PLANNING STATEMENT

Scholes Lane - ST HELENS

SUMMARY OF CHANGES FROM
APPROVED DRAWINGS

1 General-Arrangement_Plan_03-Third
1:100

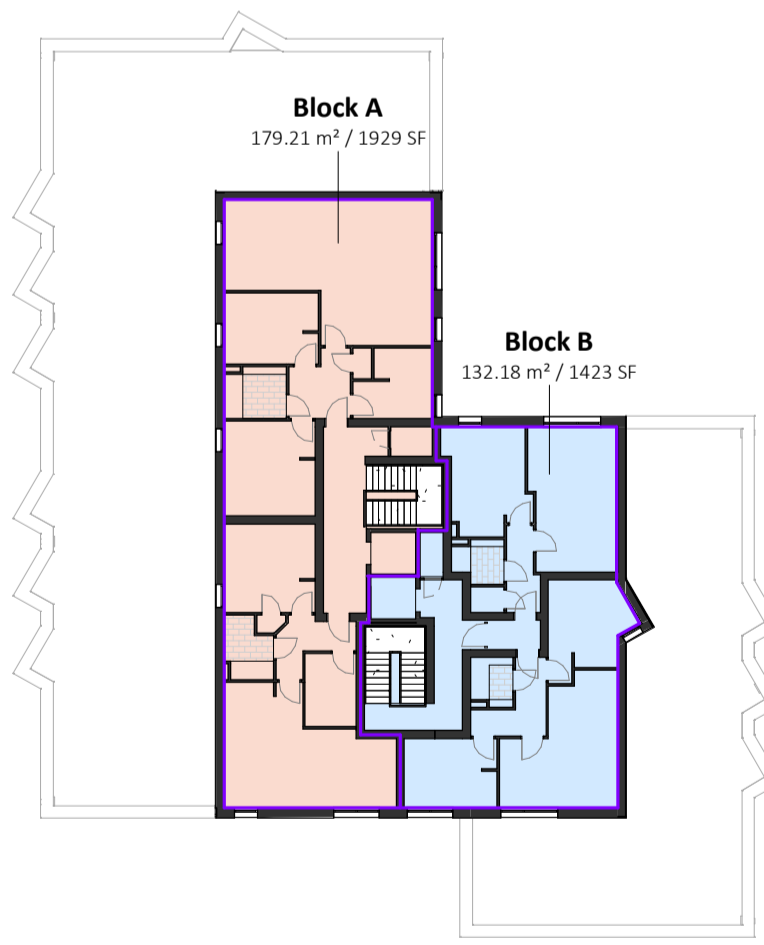
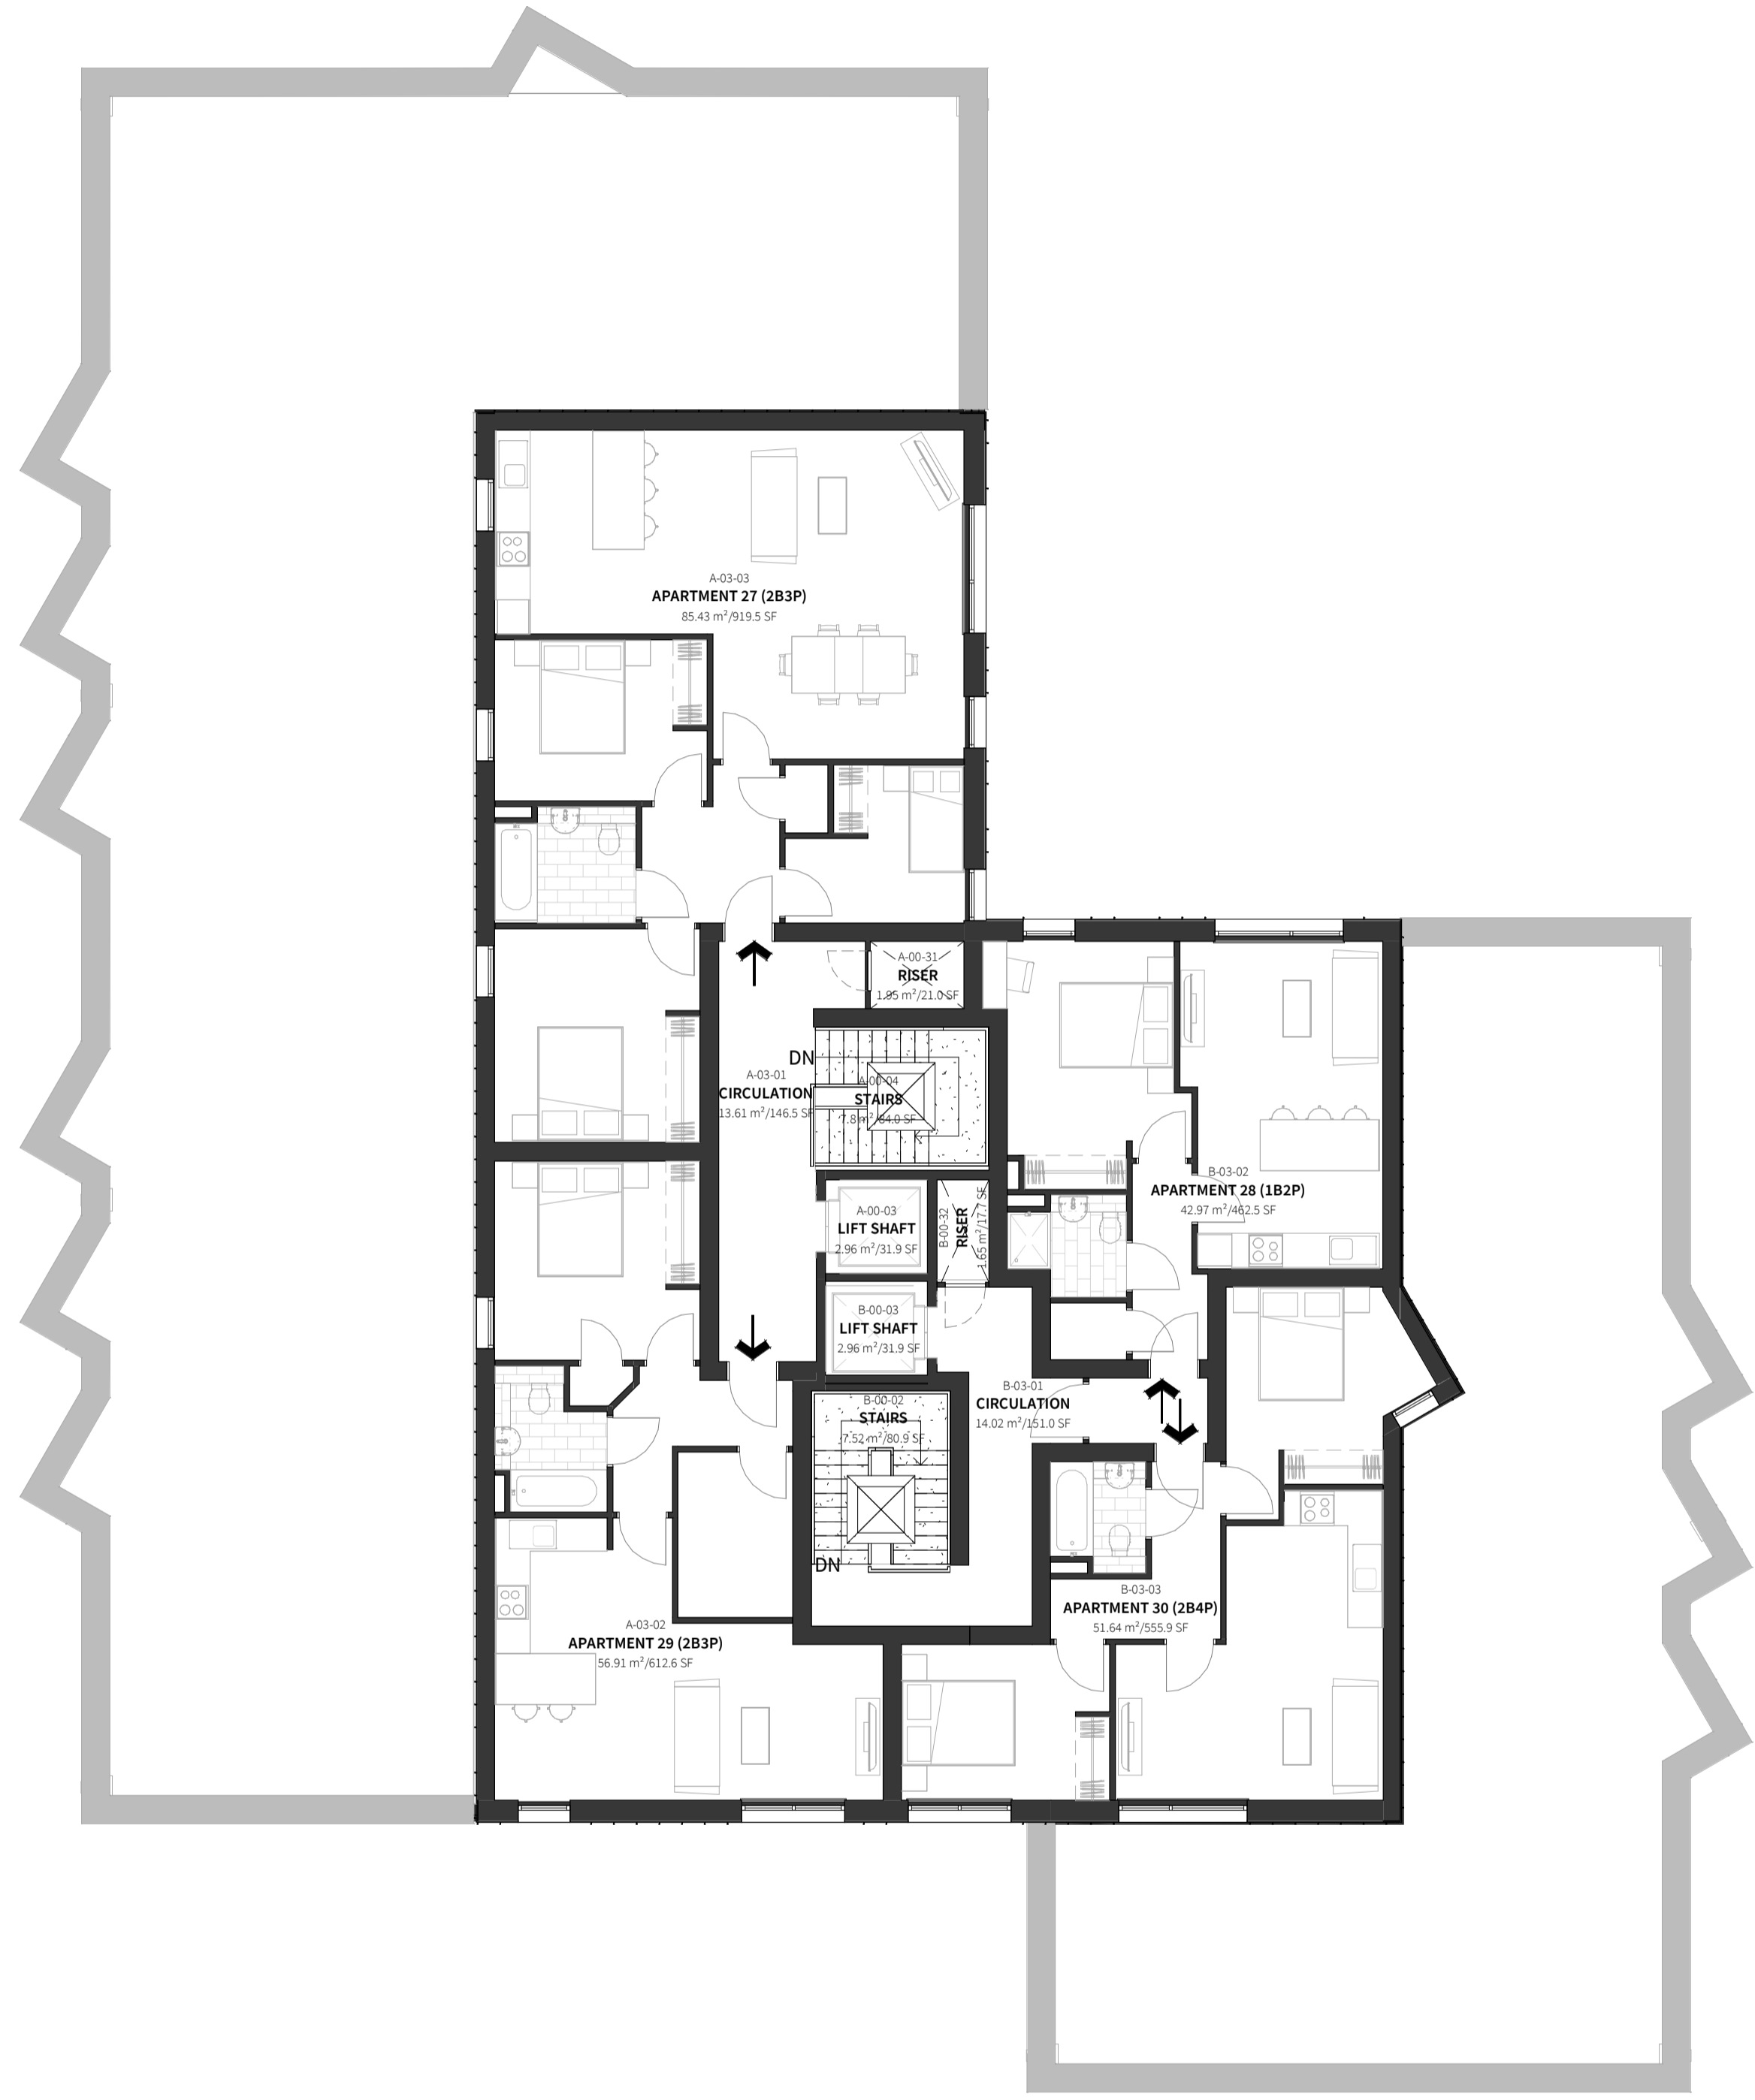
7. The top floor which is set back has now been changed in the construction and is going to be constructed from a lightweight timber frame and cladd in the dark grey aluminium cladding.

**1** General-Arrangement\_Plan\_01-First  
1:100

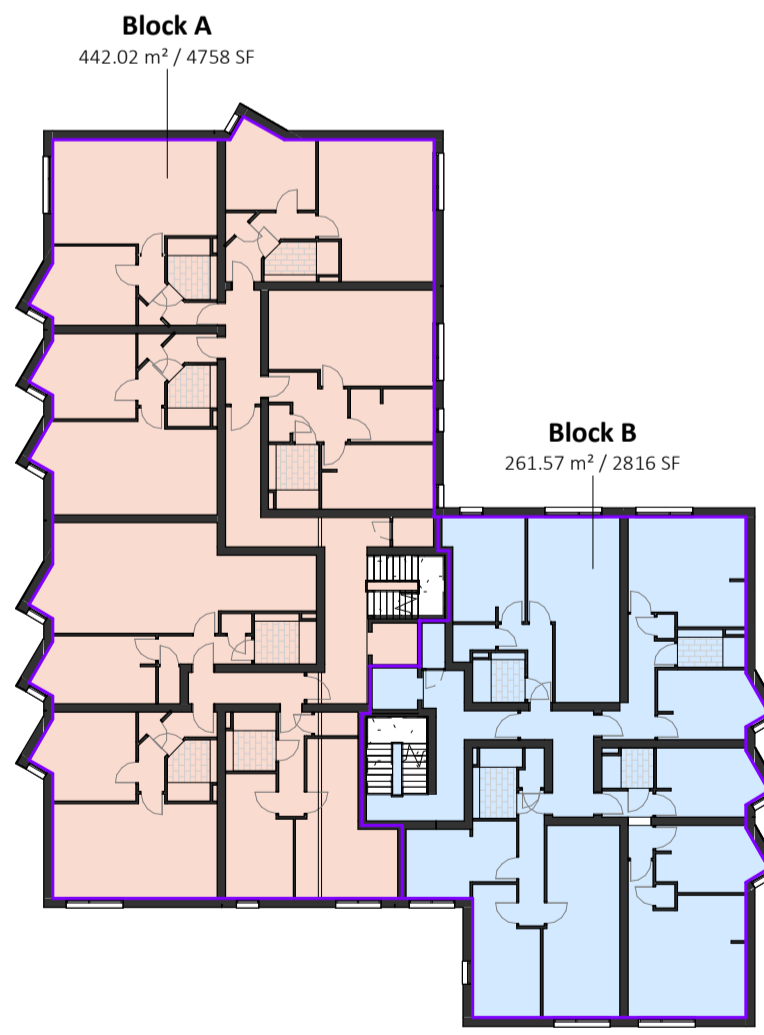
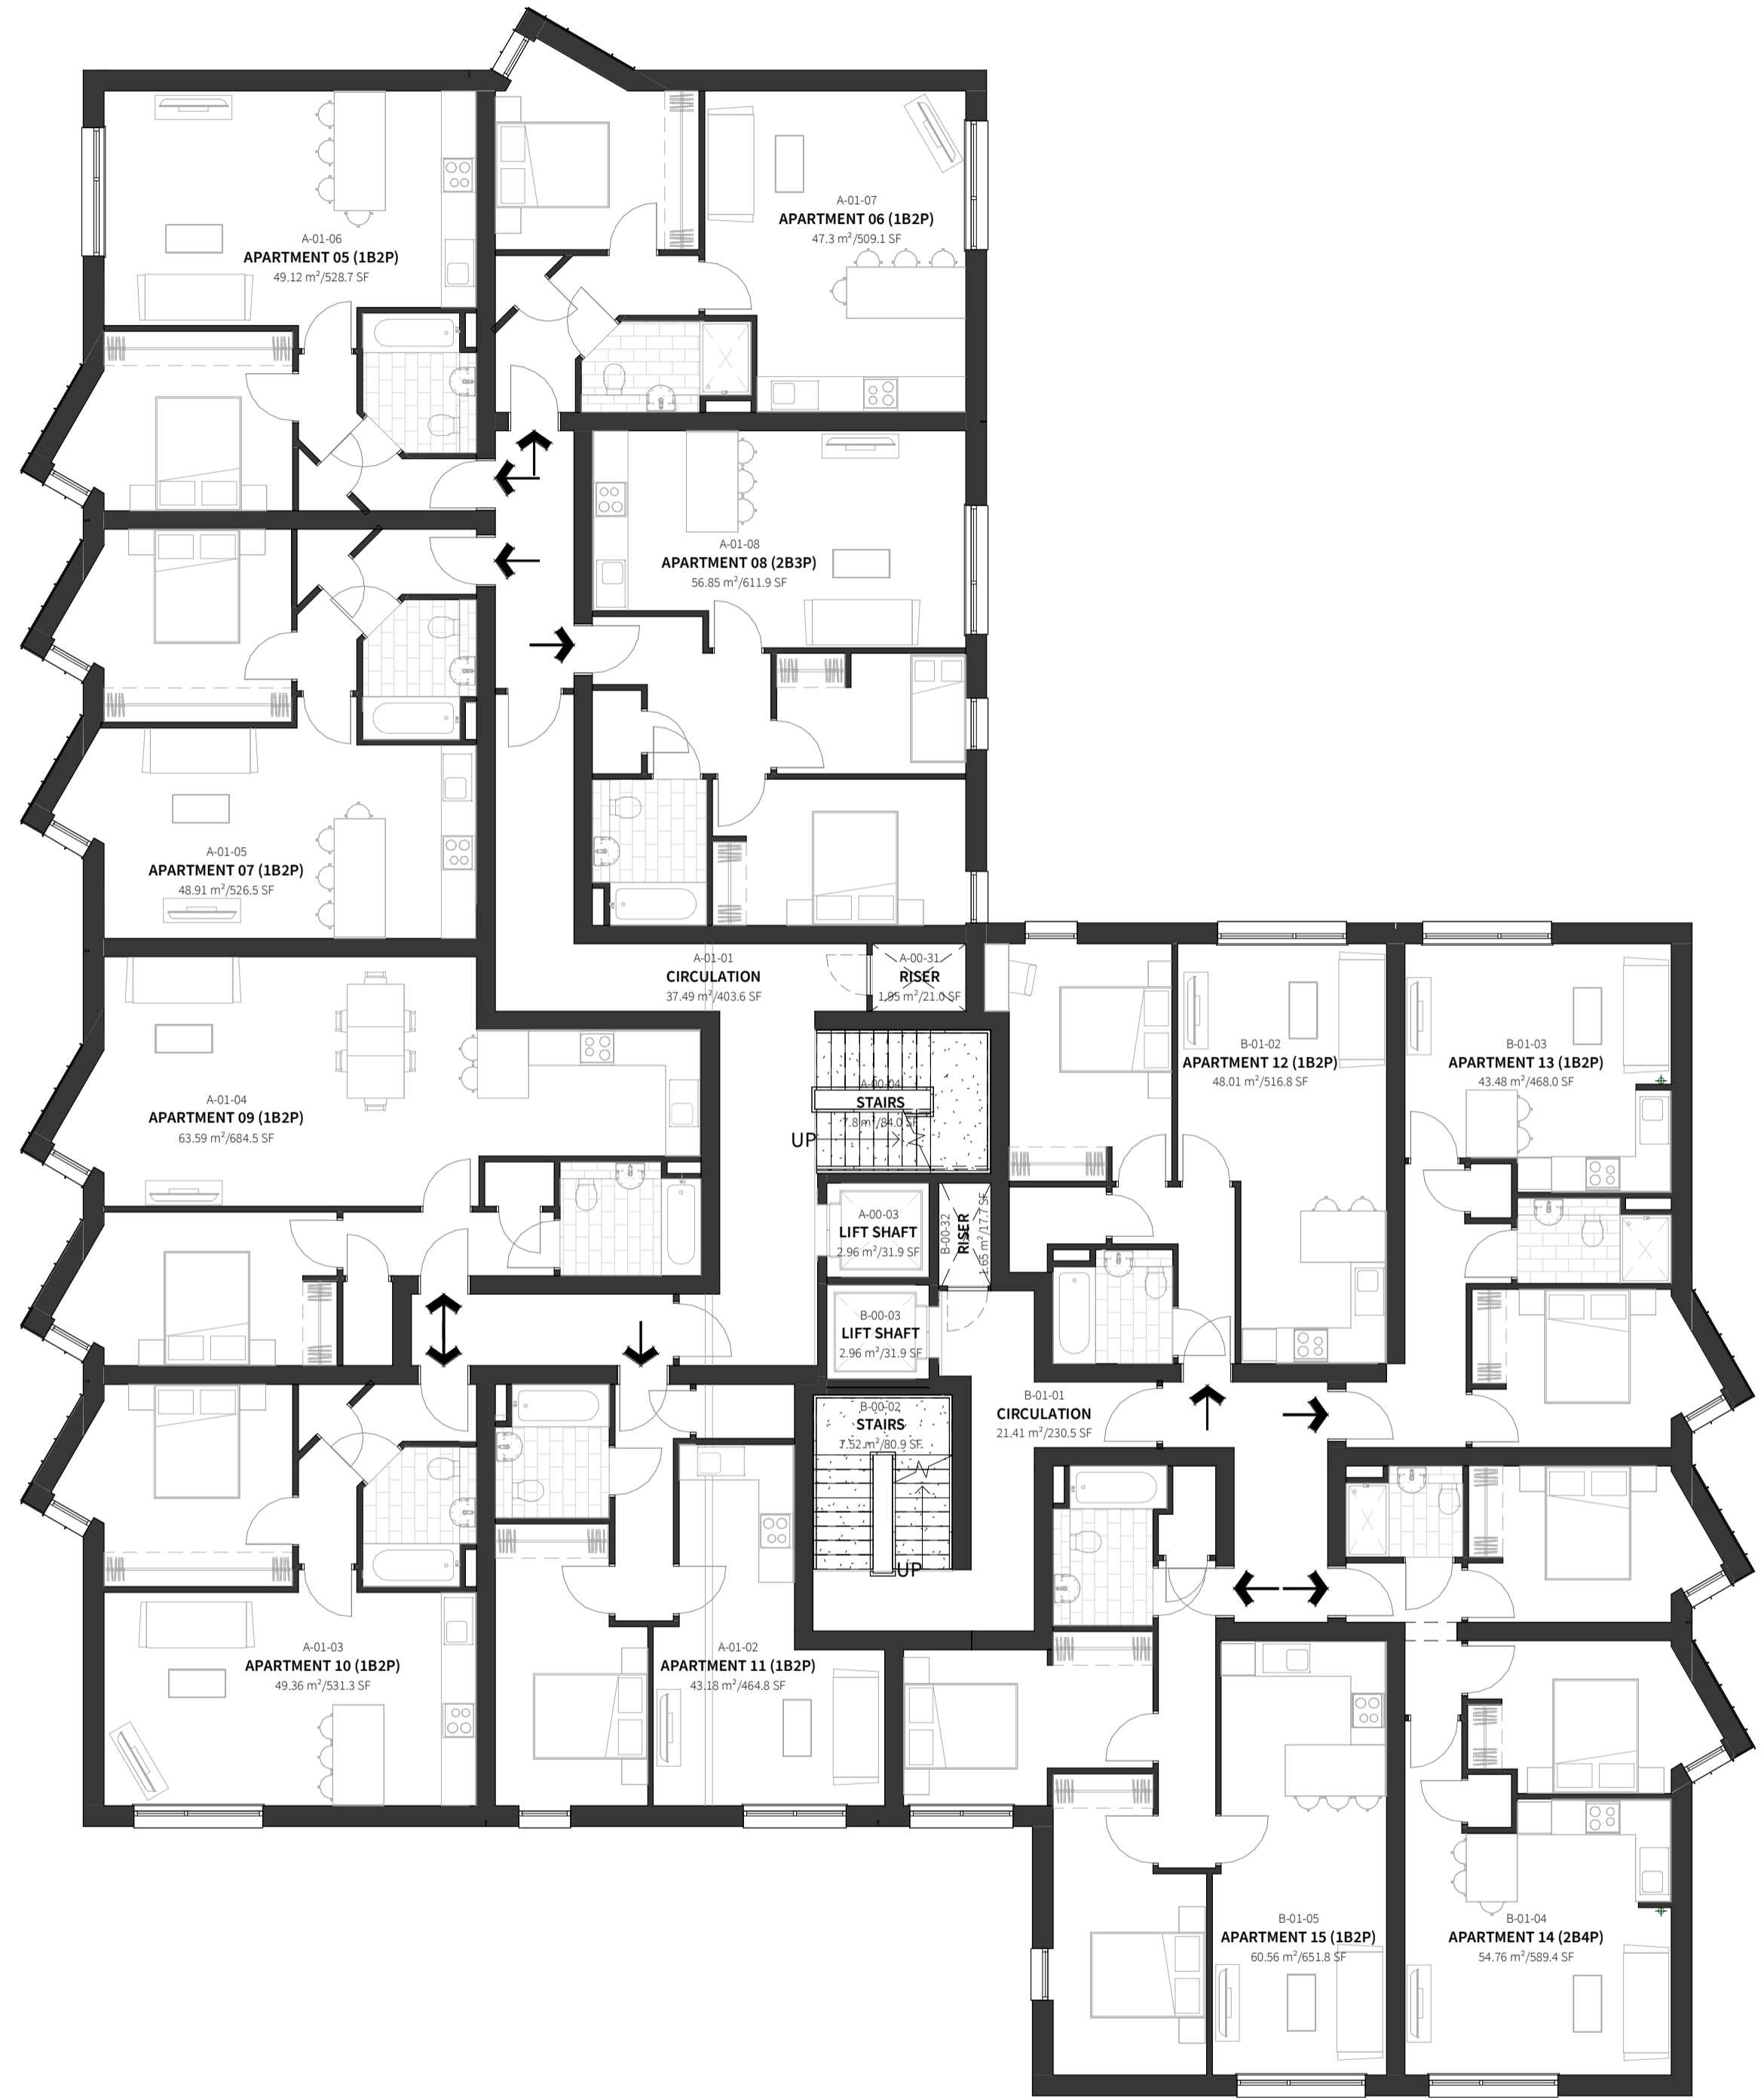
5. Apartment layouts across the floor plate have been made more efficient by reducing the corridors within the apartments. This efficiency has also been achieved through the addition of the second stair and lift. The removal of the bike store allows for an increas
